About the application

Application number: 2024/91260	
What is the application for?:	Variation of condition 2 (plans and specifications) and 35 (removal of permitted
Address of the site or building:	Land at, Merchant Fields Farm, off Hunsworth Lane, Cleckheaton
Postcode:

User comments

status: PLANNING
 project: MERCHANTS FIELD CLECKHEATON
 site: SITE LAYOUT
 drawn: QYRB. date: MAY 2019
 checked: RB. scale: @ A0:1:500
 job no: 122. dsg no: 122-PL-01-V

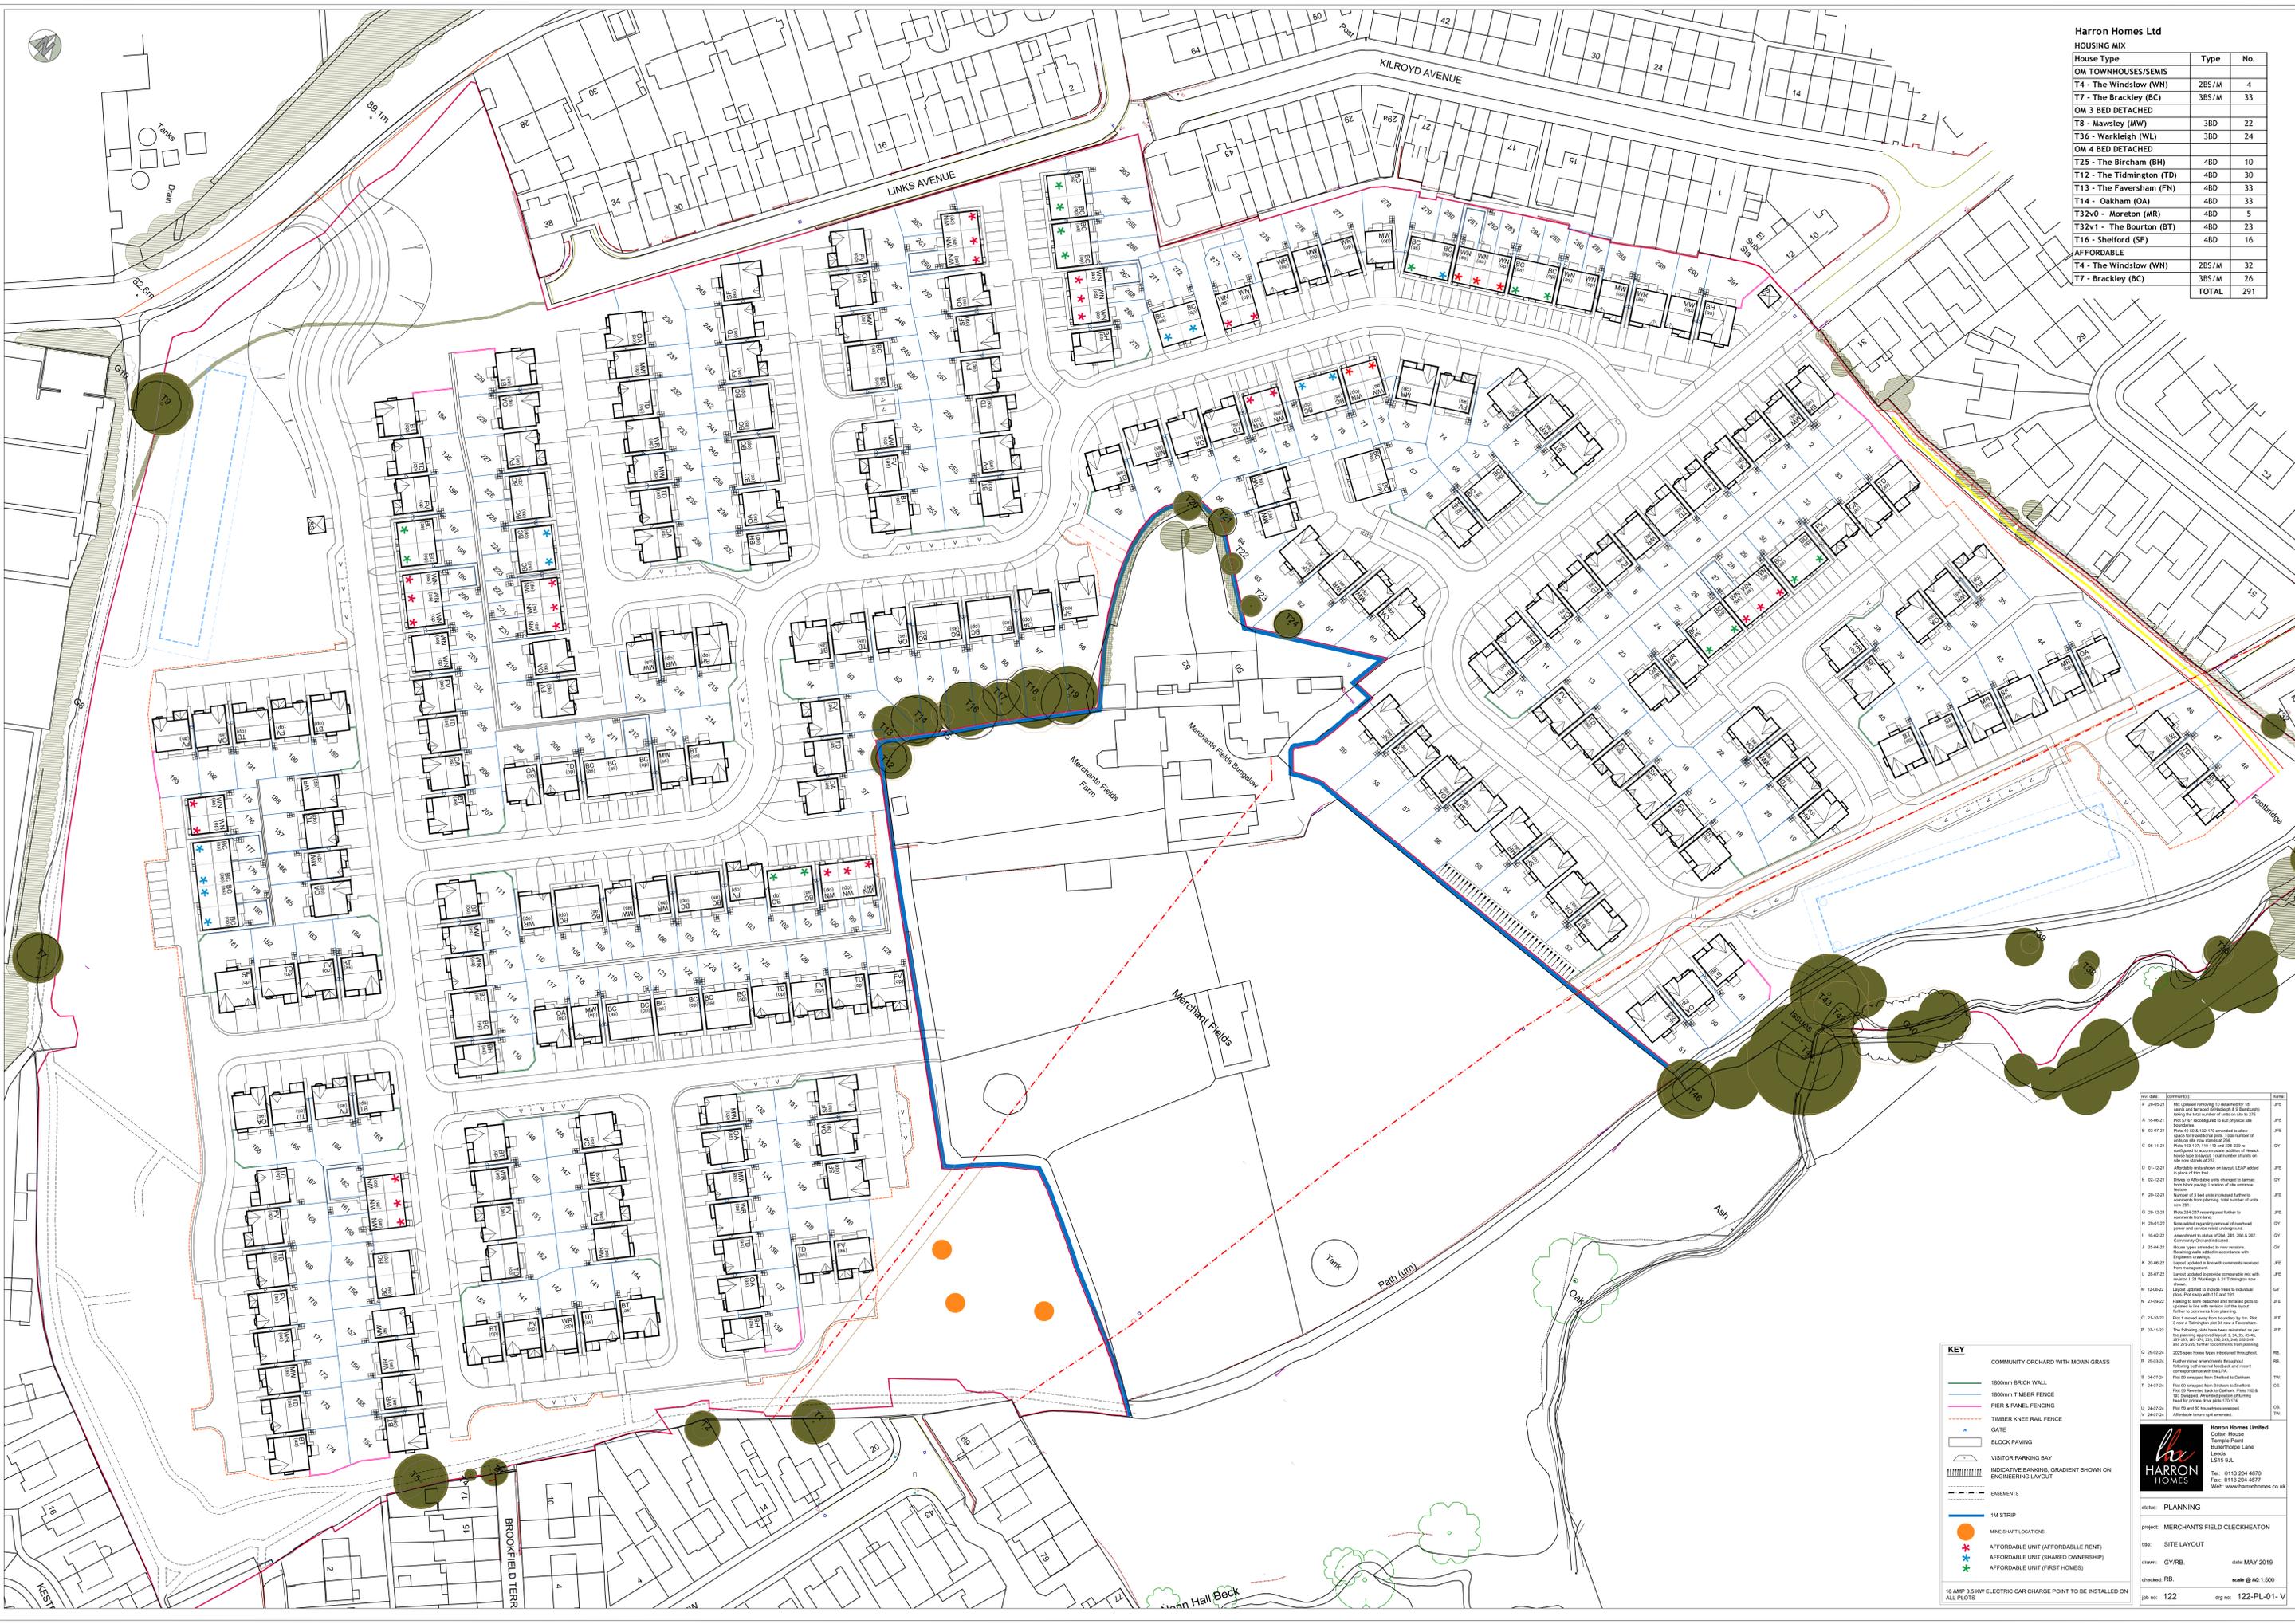
In the plans, to me, the garden border of the new house and its proximity to the bungalow on merchants' farm appears unacceptable. It appears extremely intrusive to the existing bungalow, already refuse vehicles, postal, and delivery vehicles have turning difficulties at this exact location.

However, I am intrigued on one of the new plans submitted in this exact area of the privately owned field there is a big blue area which doesn't have a description as to what it is, could this be the so called lake?? From overflow water tanks? What happens if lake overflows?

At the bottom of the Mazebrook field just near the public footpath route, before and beyond the stream. New HH plans submitted show wooded picnic areas, benches, woodbark paths, play area etc. Knowing this area very well, it's completely unrealistic as the area becomes totally flooded during flash rainstorms or persistent rainfall and has done for years. Evidence of this are mature trees have fallen down here due to the saturated ground.
